From: [Jan Anderson](#)
To: [Sunnica Energy Farm](#)
Cc: [Nick Wright](#)
Subject: Sunnica Soil
Date: 16 December 2022 14:40:25
Attachments: [image001.png](#)
[image002.png](#)
[image003.png](#)
[image004.png](#)
[image005.png](#)
[image006.png](#)
[image007.png](#)
[SD4 \(4\).zip](#)

Sunnica – Deadline 4
Ref Nos: SUNN - AFP 191

Please find attached (appendix 1) the speech I made at the Open Floor Hearing on Friday 9th December. I have set out below in points A to E the evidence to support the points made in my speech and my conclusion that the report submitted by Daniel Baird Soil Consultancy Ltd's known as 'Soil baseline report Appendix 12B' has a series of failings that mean it cannot be relied upon to assess BMV on the Sunnica site.

Sunnica Energy Farm Proposed Layout - (Predictive BMV Land Assessment)

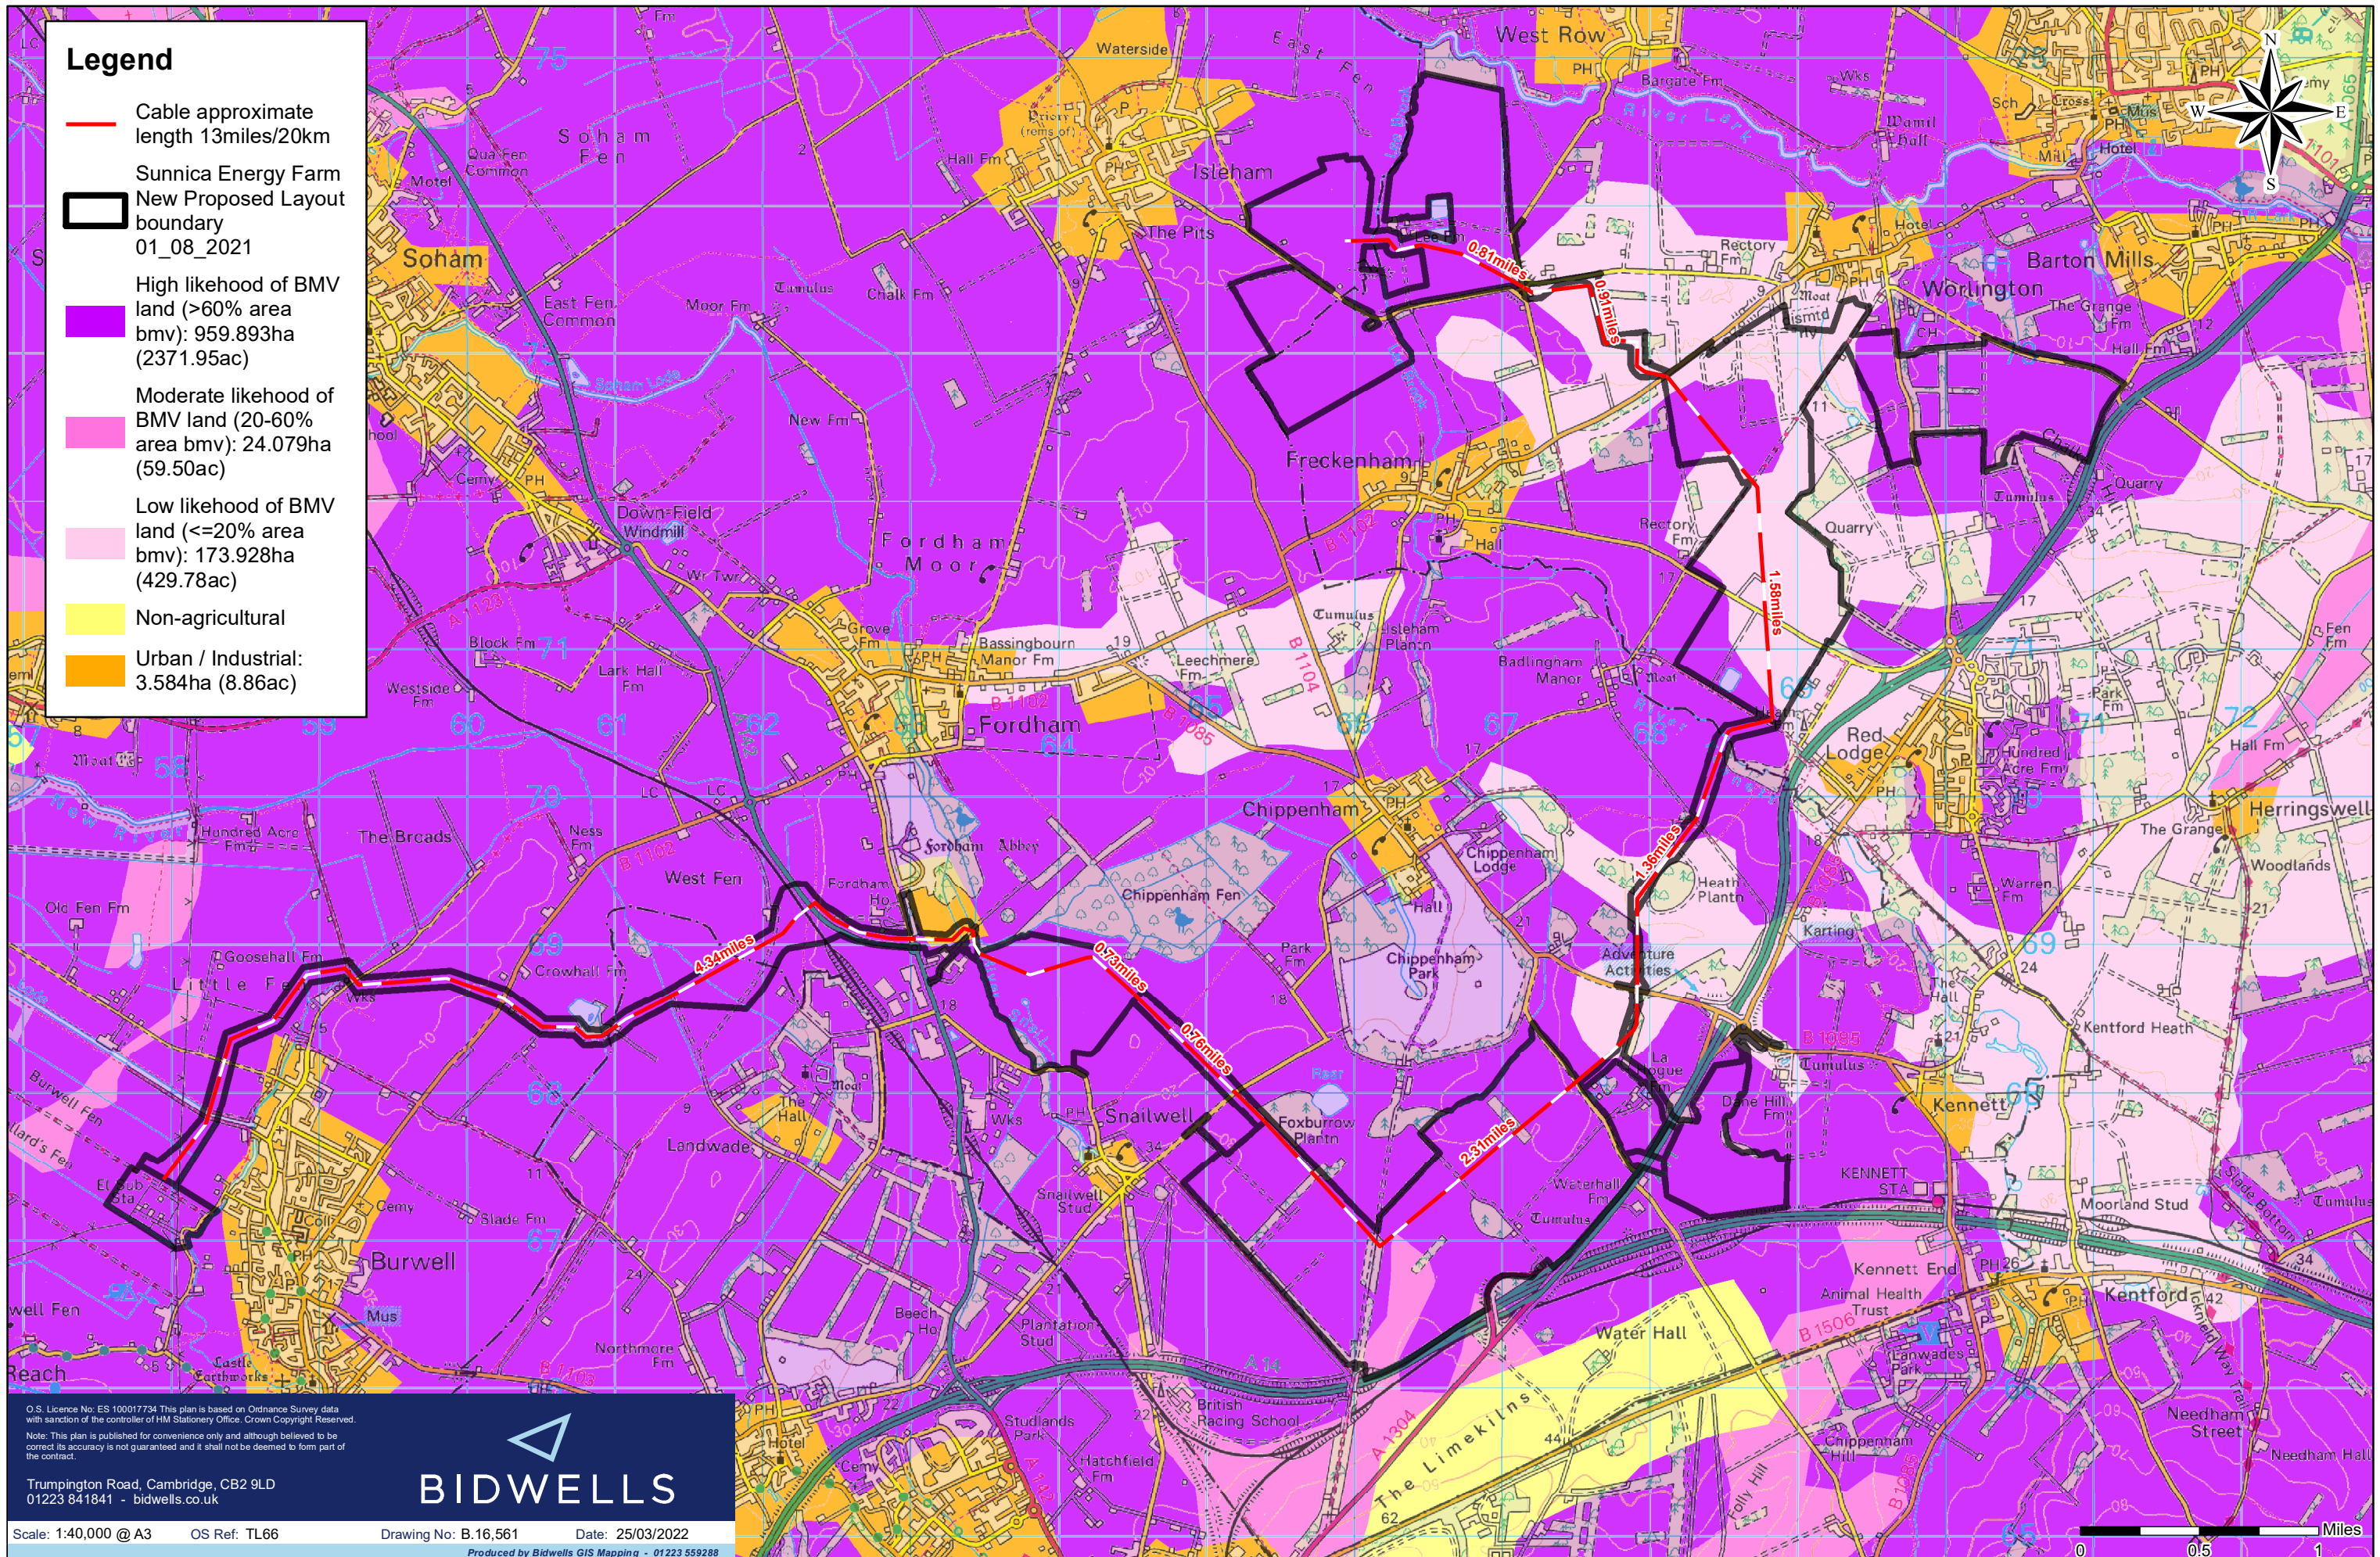
4/ DB finds only 37ha of BMV – ALC predictive plans and Magic maps suggest at least 50% of the site is BMV.

5/ ALC grading is at odds with the background checks. DB's own report describes varied flexible cropping throughout the site which is entirely consistent with BMV land. DB has only found 37ha of BMV over the whole site. Please also see (appendix 3a 3b & 3c) an email to Natural England dated 8/12/2022 to John Torlesse setting out the inconsistencies of DB's report set against the ALC plan, and Natural Englands Predictive BMV Land Assessment.
